Response to WSCC Strategic Planning Consultation Comments dated 6 September 2012

**Roundstone Lane, Angmering
Arun Planning Application A/82/12**

Barratt David Wilson Southampton

23 November 2012

**Summary of Traffic Survey Data, Queue Length Data and  
Junction Geometry Drawings**

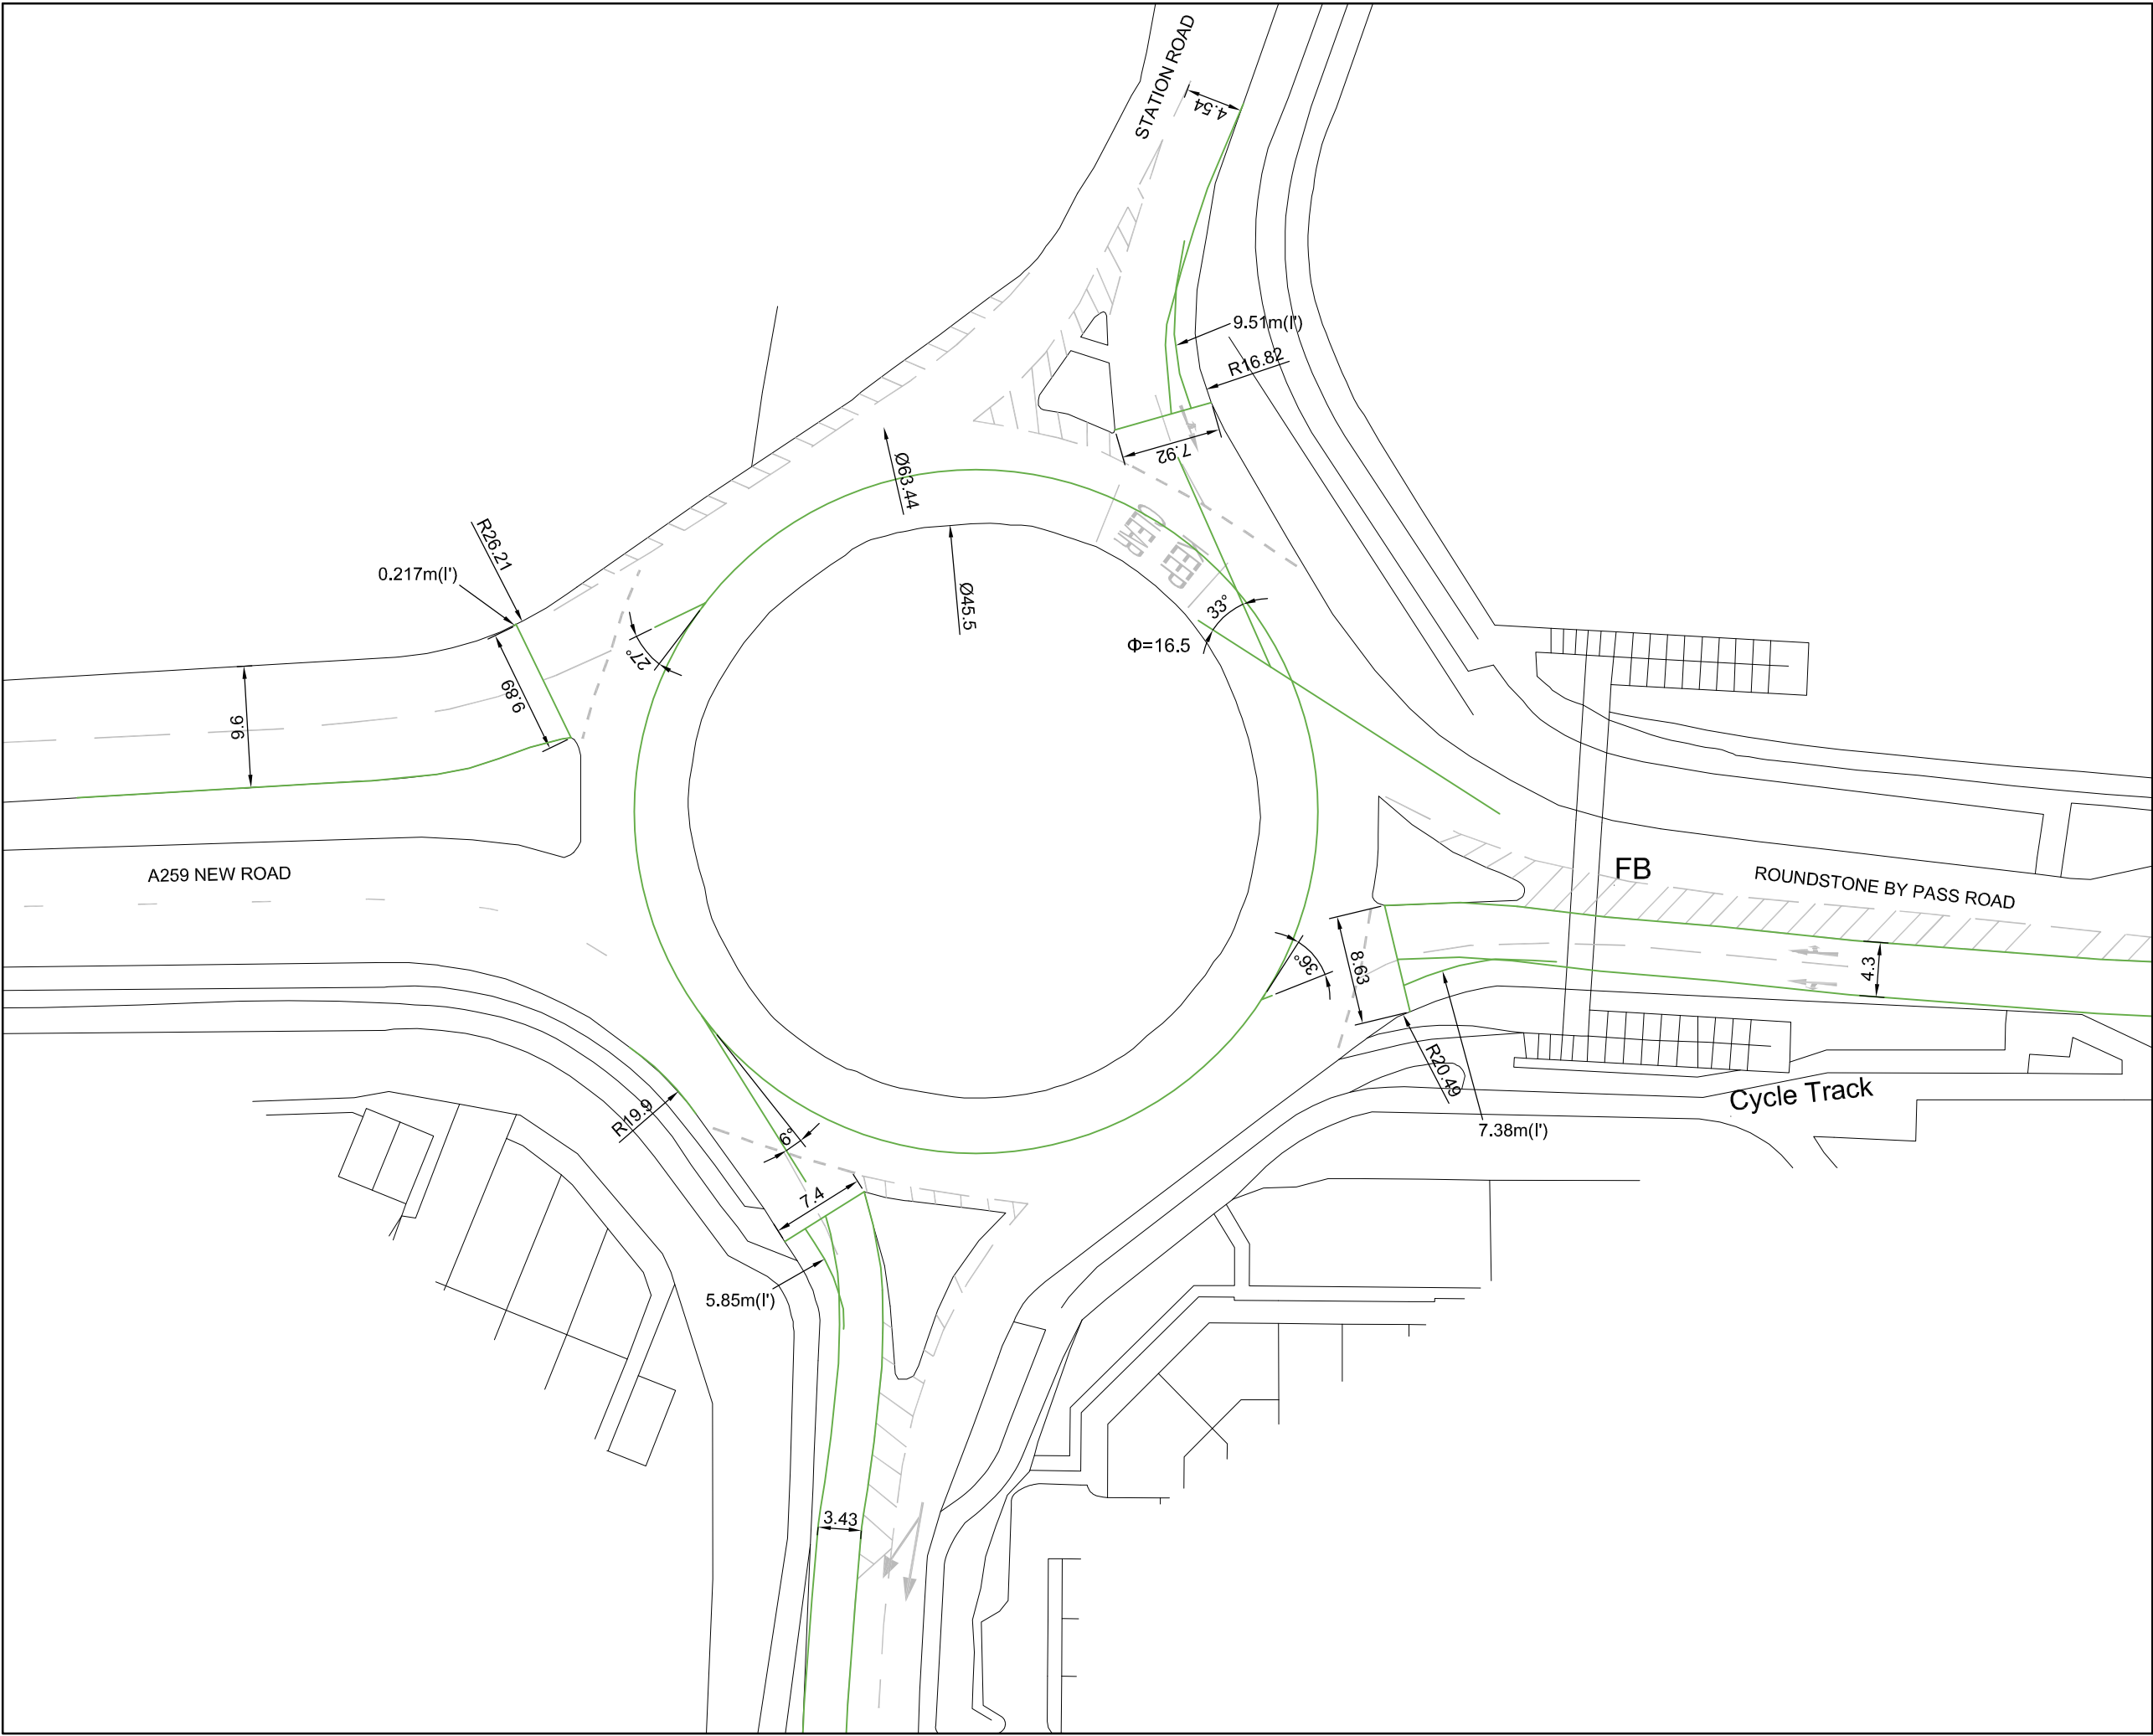
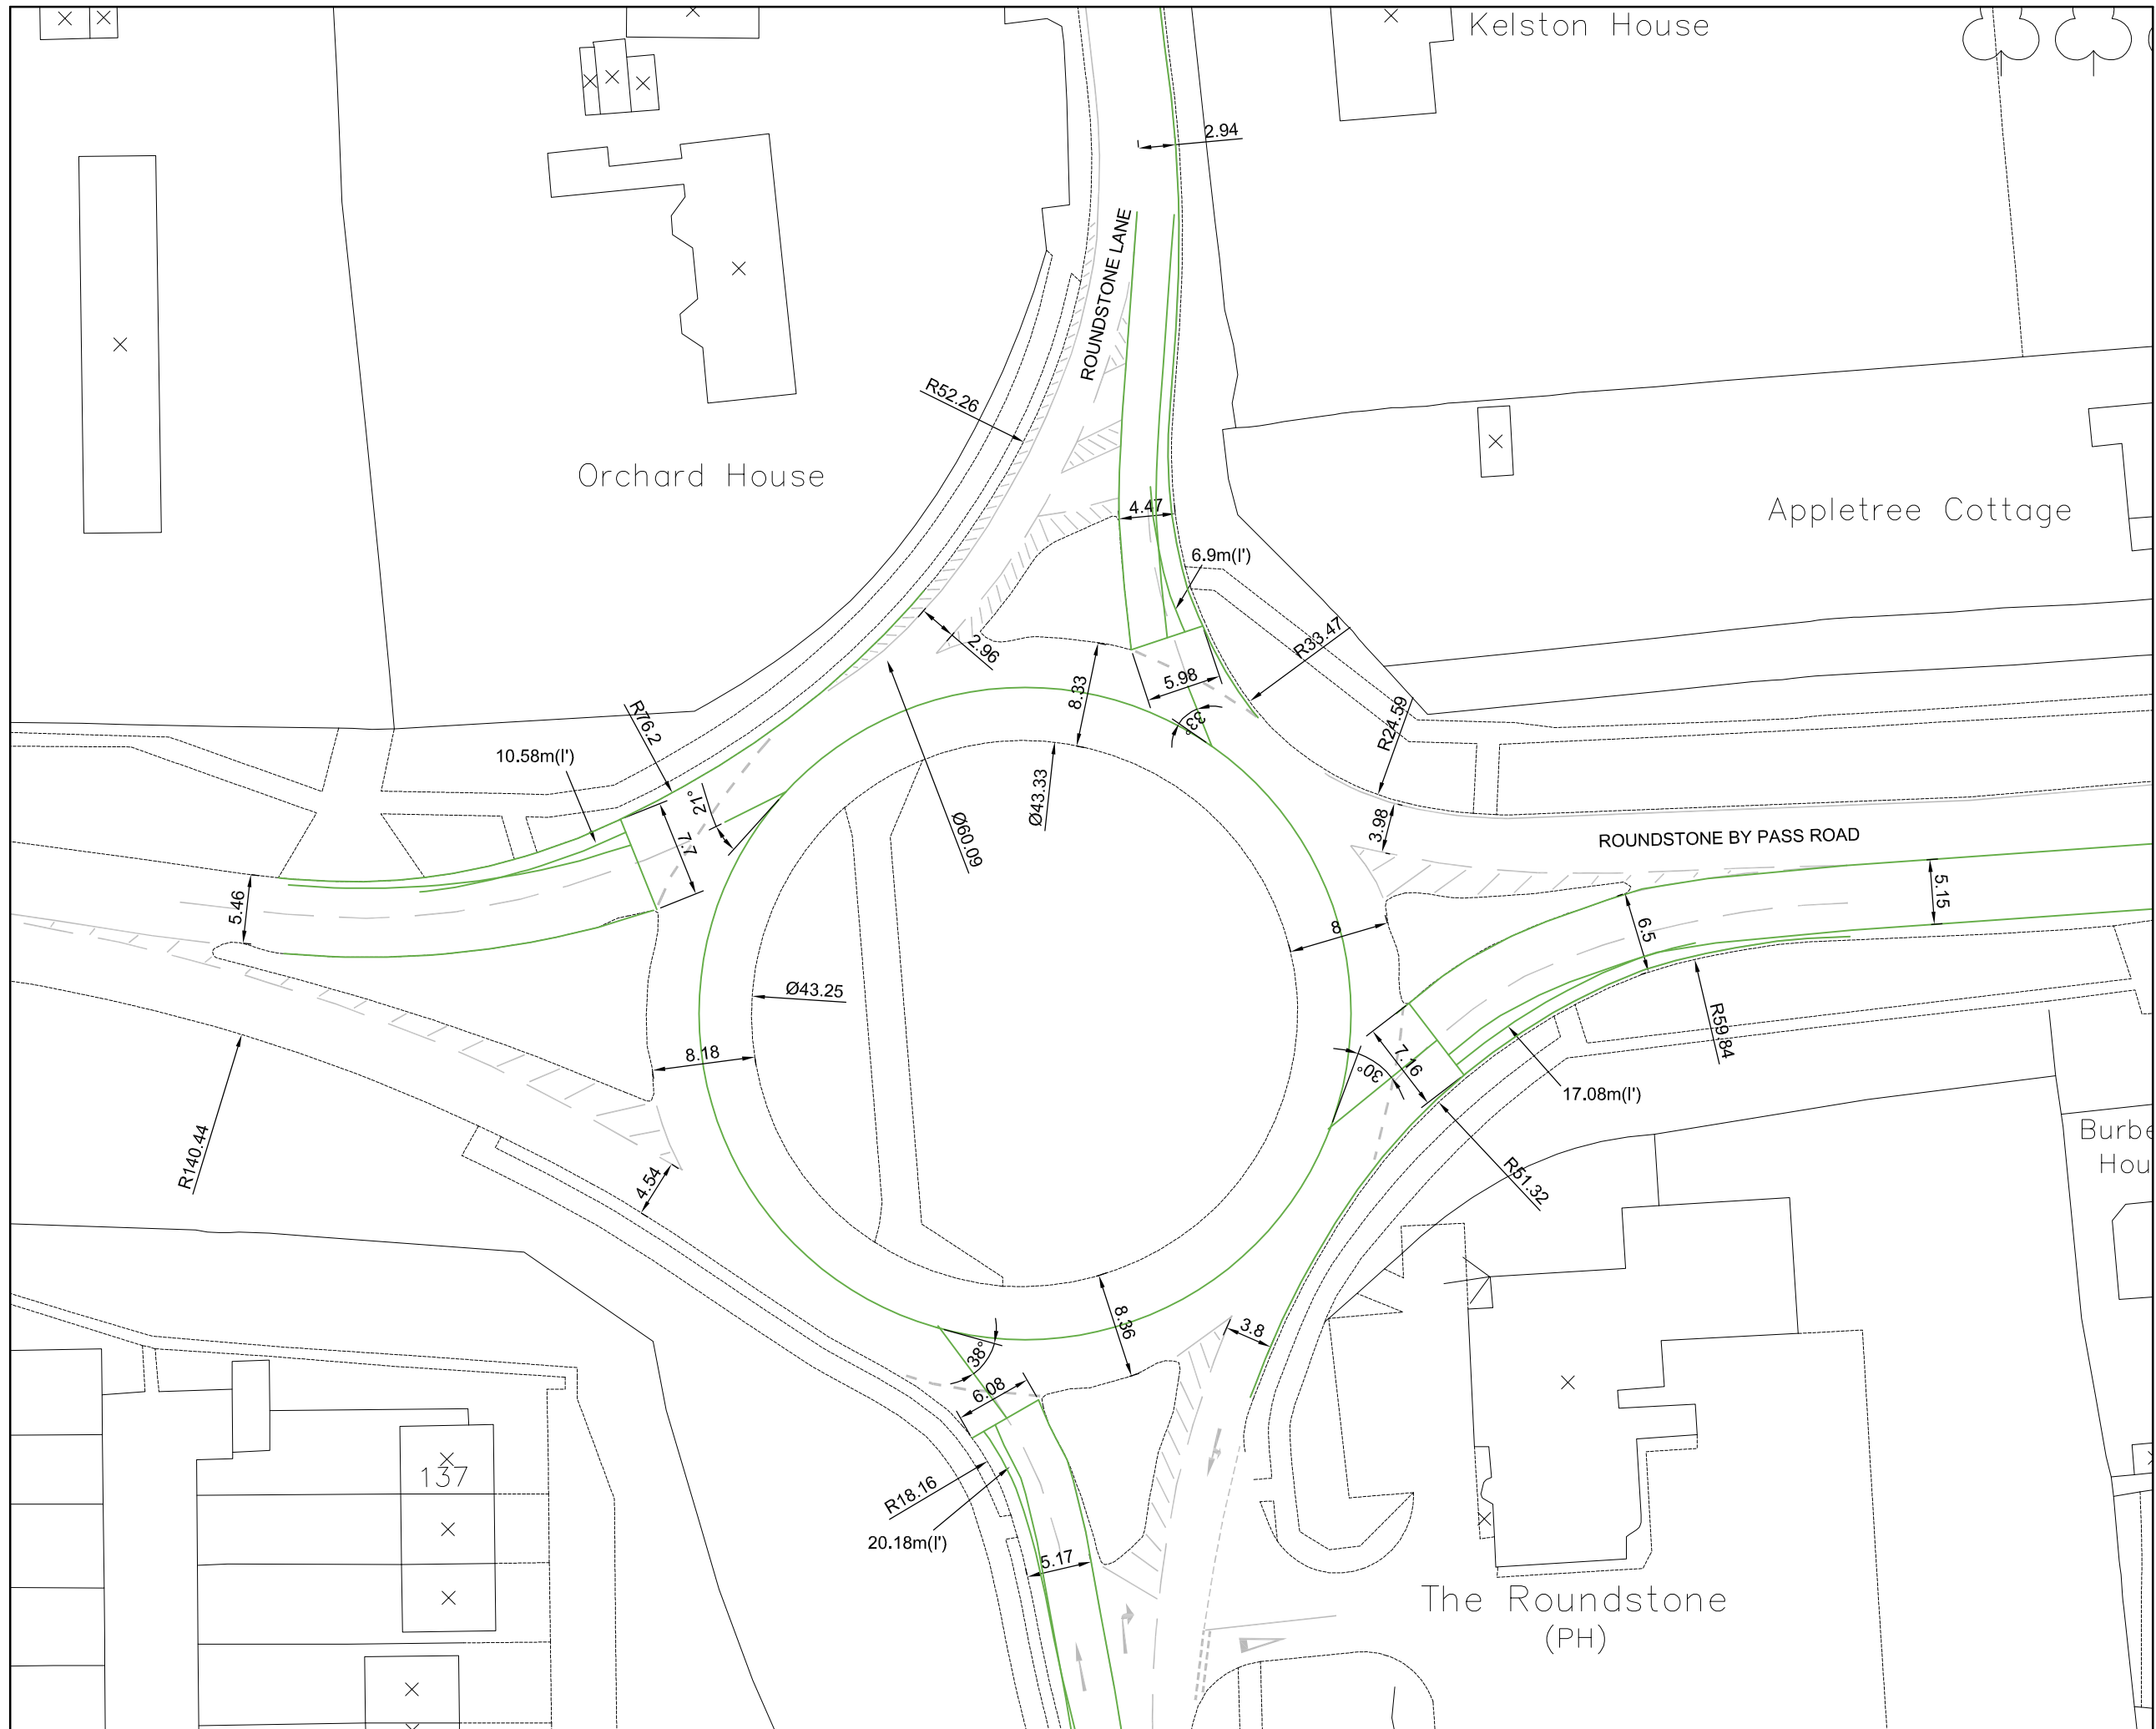
Junction assessments: These do not appear to be consistent with observed traffic conditions on the A259 or at Water Lane/A283. The queue lengths in Appendix 11 appear to be lower than actual observed queue lengths during the morning and evening peak hours. Further detail should be provided on the junction assessments relating to the A259 to explain the relationship between observed congestion and the technical junction assessments.

Queue length data taken during the traffic survey together with a summary in table and also schematic format is attached in Appendix 1 at the rear of this note.

The observed lengths in vehicles were noted every five minutes by the survey company. The summary queue lengths compiled by us from this data are mean average PCUs to match the definition of queue in TRL's ARCADY method. Capacity models are based on geometrical measurements taken from Ordnance Survey and aerial photograph. Percentage arm capacity adjustments have been undertaken where necessary such that the output from the ARCADY base model shows similar results.

We believe this industry standard approach provides adequately representative models however there are two reasons the traffic conditions observed might differ from the modelling results which are worth noting before attempting to produce more 'accurate' models:

1 – Natural variance and definition of queue. The queues reported from ARCADY are mean average static queues over time segments. This does not include slow moving traffic approaching a junction or demonstrate the maximum observable number of stopped vehicles at any particular time or any particular day. It can be seen from the raw queue length data that as expected at peak times there is a significant variance in queue length. There would also be significant daily variance not able to be incorporated into the models.

2 – Congestion from downstream delays beyond the roundabouts may have been observed which is not a capacity failing of the roundabout itself and would not be appropriate to artificially throttle the performance of the roundabout to mimic this since alteration to that roundabout would not solve the problem.

Nevertheless we believe the models represent the geometry and delay on the ground and produce a fair assessment of the likely increases in queue and delays due to development which are of course small in proportion to the small increase in traffic flow due to development.
